SSD 7317 MODIFICATION 3 – RESPONSE TO SUBMISSIONS

This Response to Submissions report (RTS) is submitted to the (the Department) in support of Modification 3 to amend State Significant Development (SSD) consent SSD – 7317 relating to the construction of a commercial campus at the Australian Technology Park, Eveleigh.

1 DA SIGNAGE ELEVATION - WEST
1 : 200

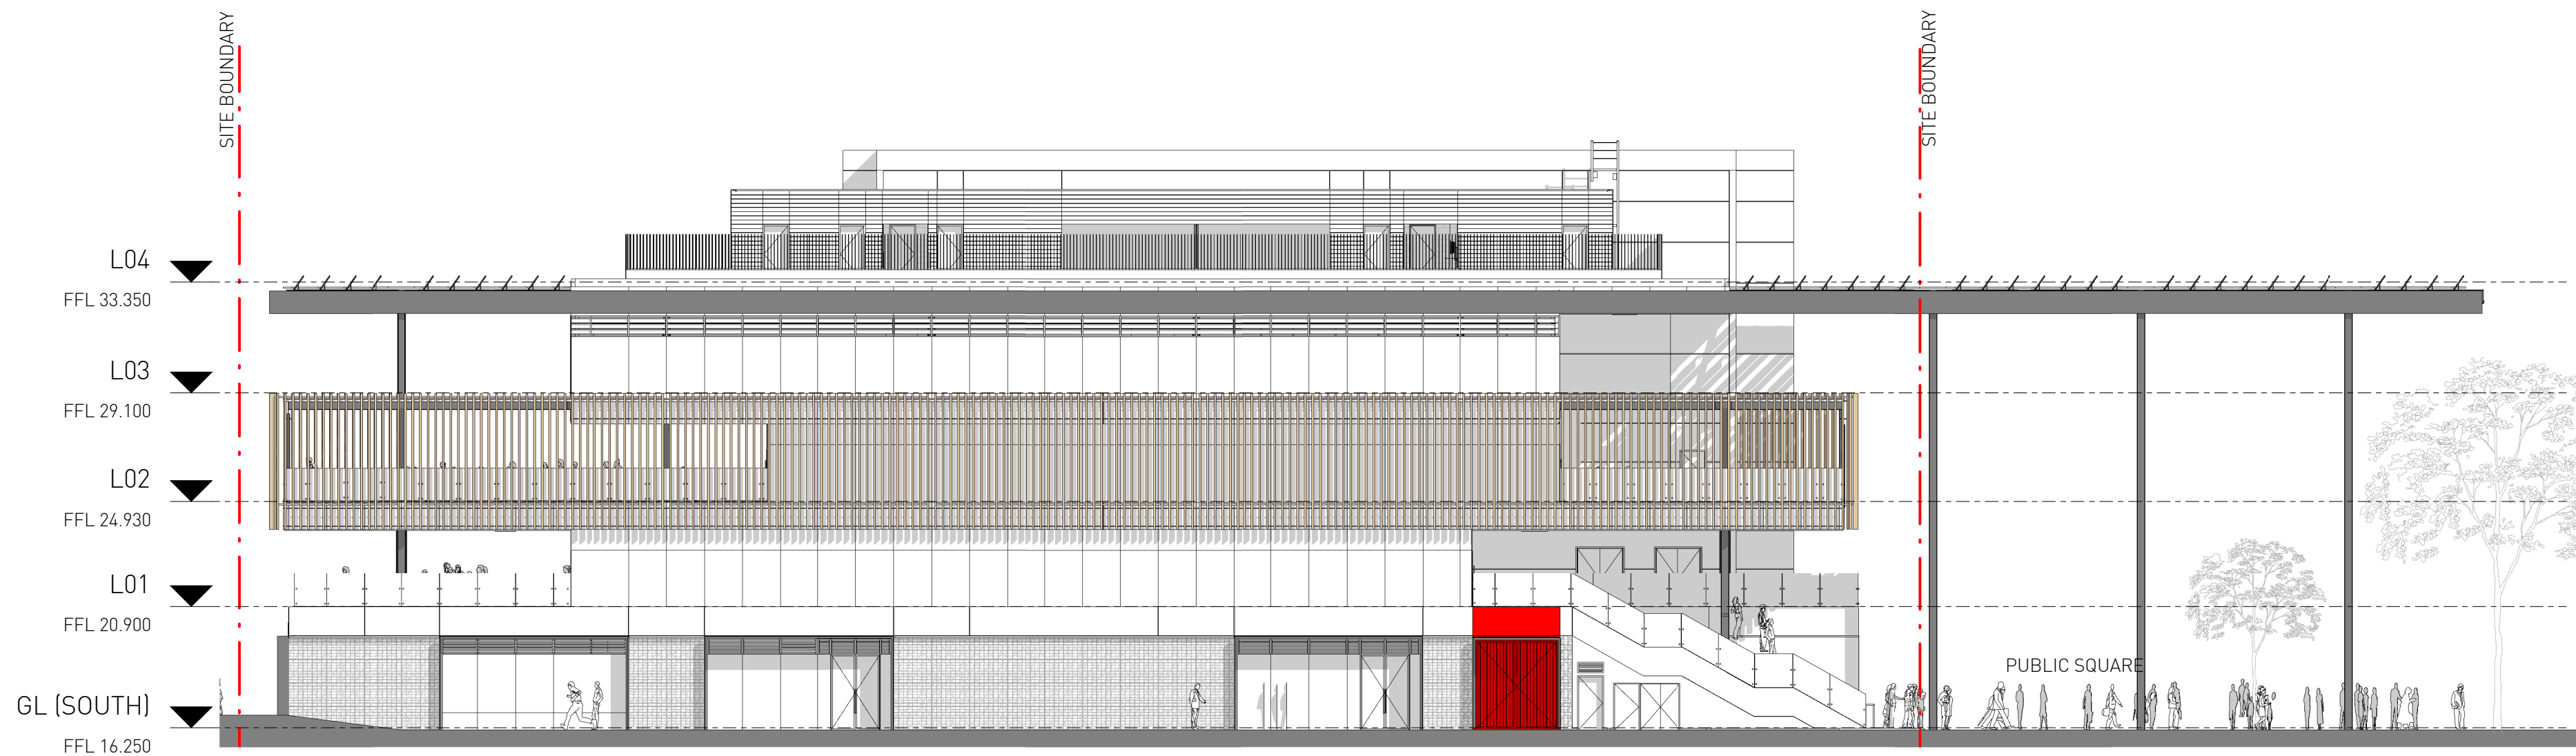
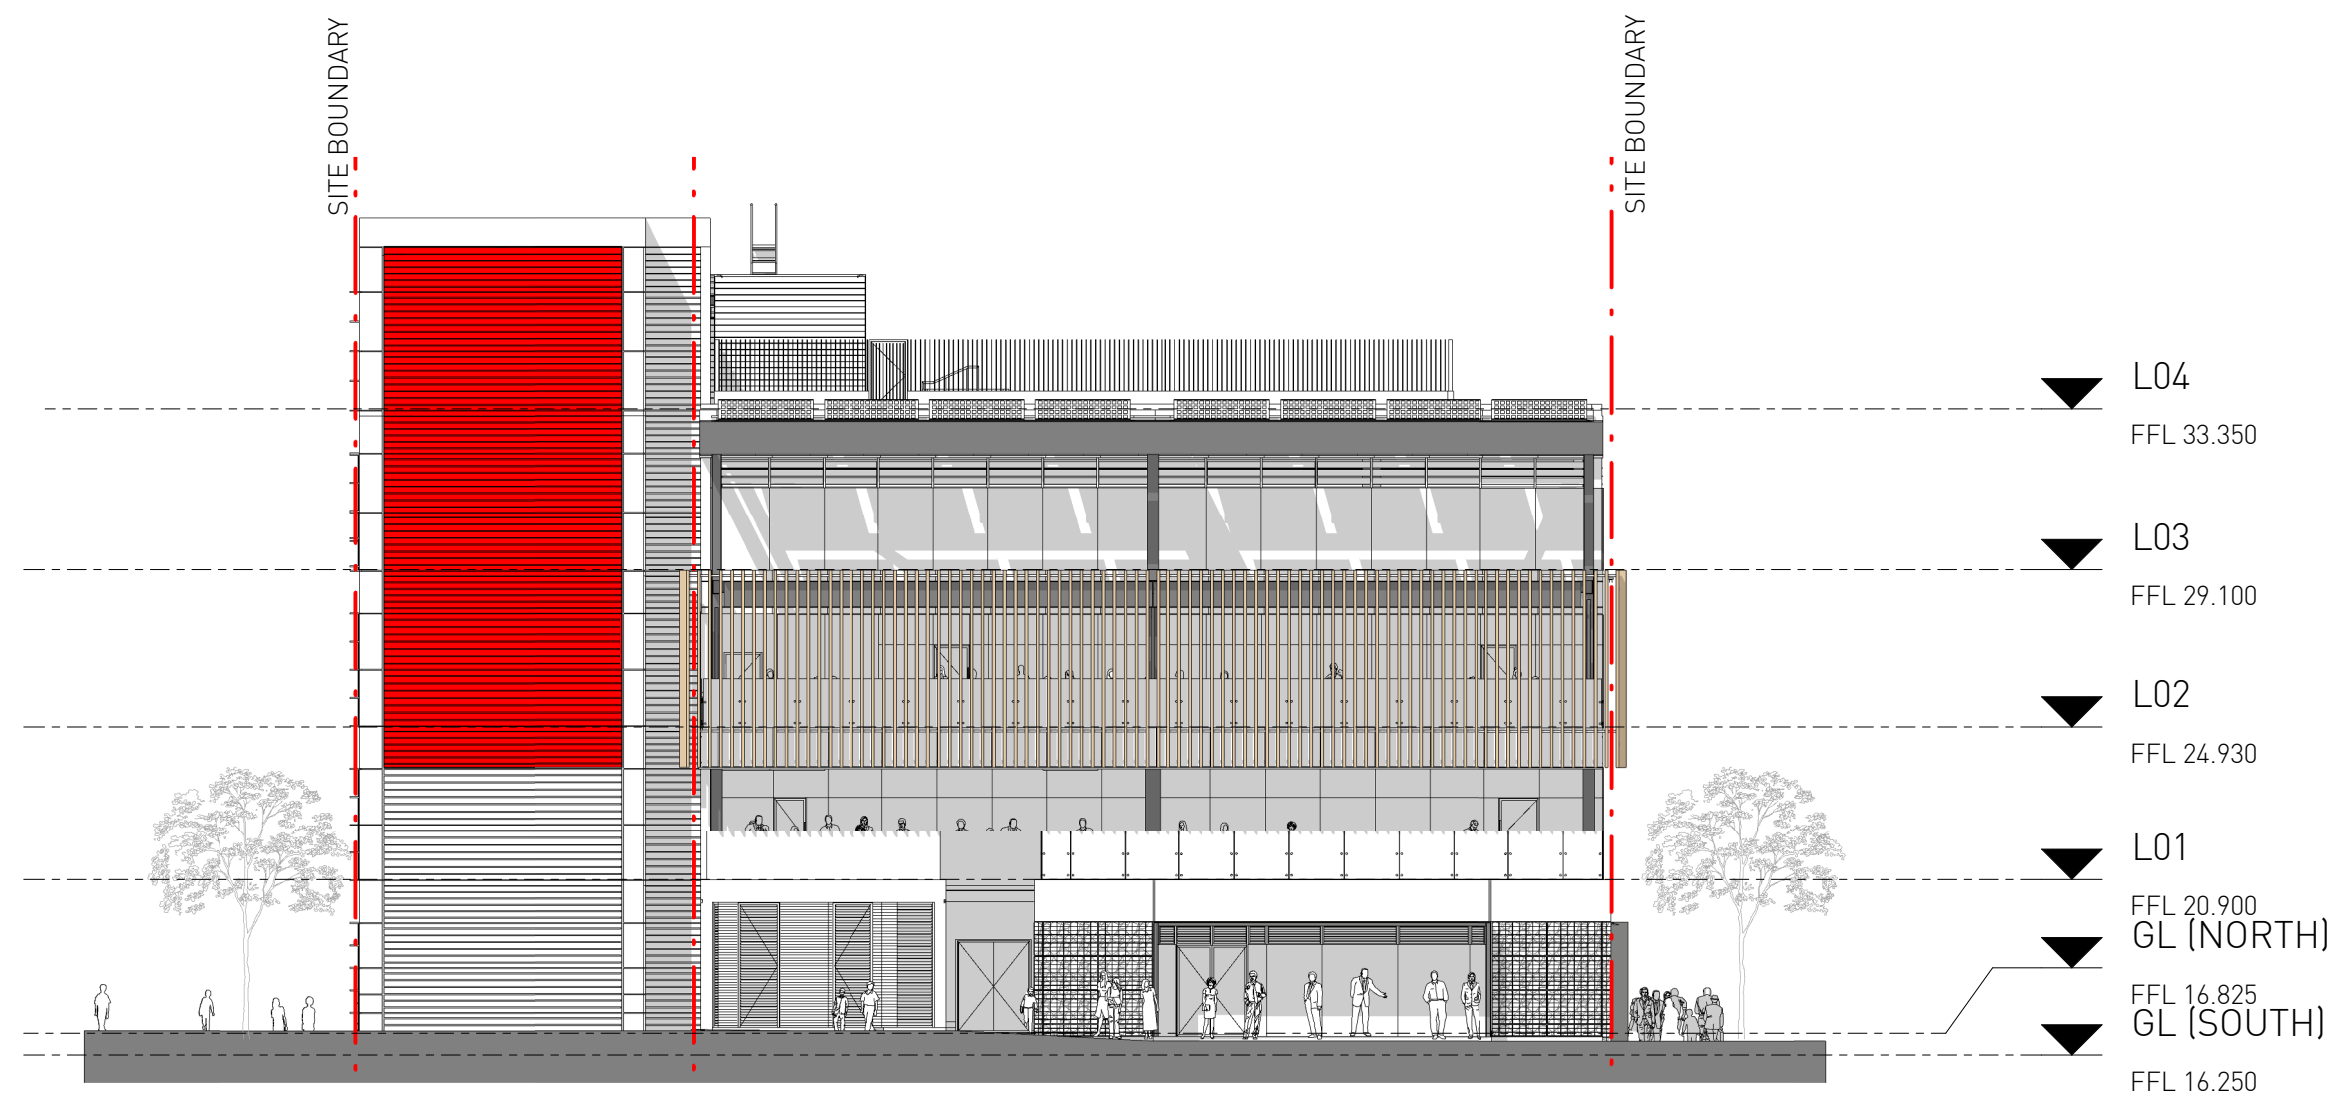
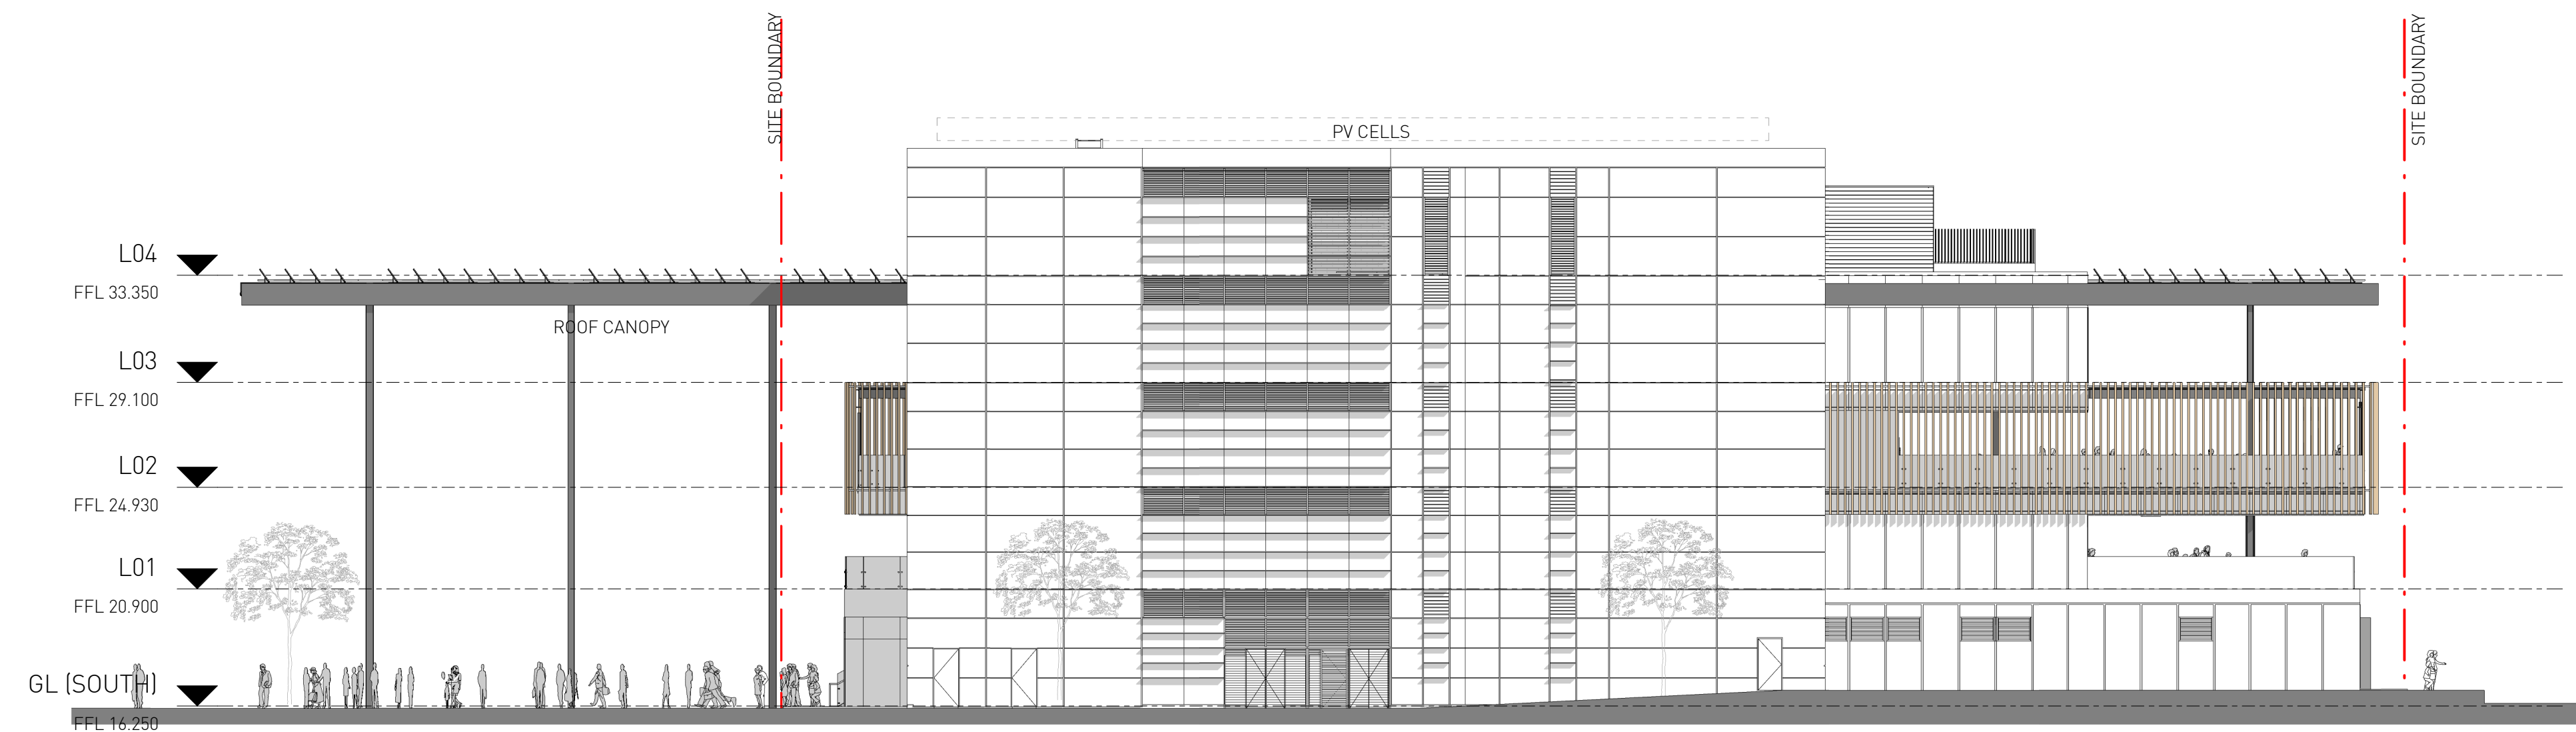
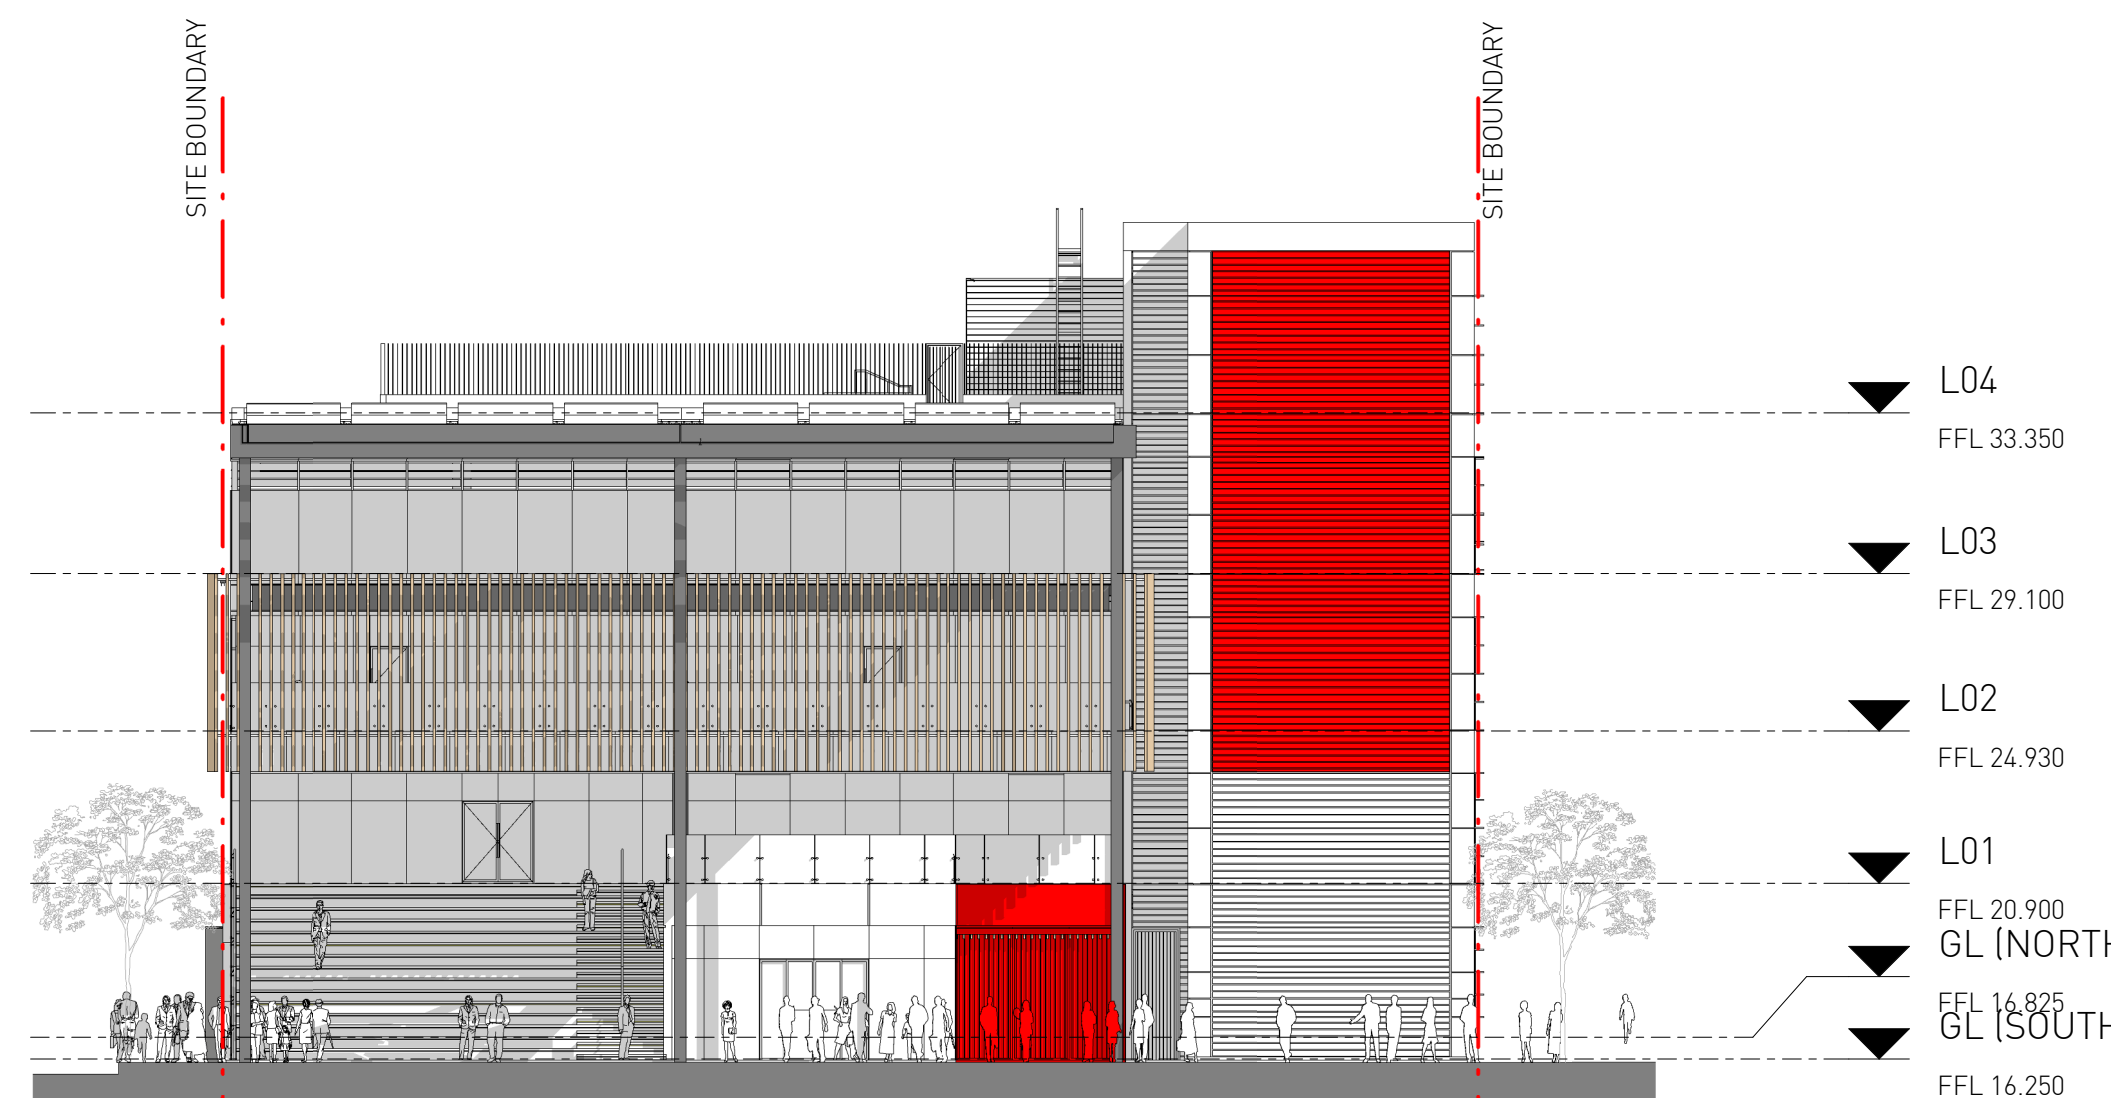
Further detail is required on the type of signage proposed for the signage zones, including the extent of these zones and to consider reducing their dominance, giving consideration to Council's comments.

The proposed signage zones indicate potential locations for signage only. As per Condition F7, detailed signage plans will be provided to the Department for approval prior to installation. The signage zones have been reduced in size as shown in the updated signage plans and signage details provided at **Attachment B**. A future approval for signage and content will be submitted to the Department. It is too premature at this stage to determine the detailed design.
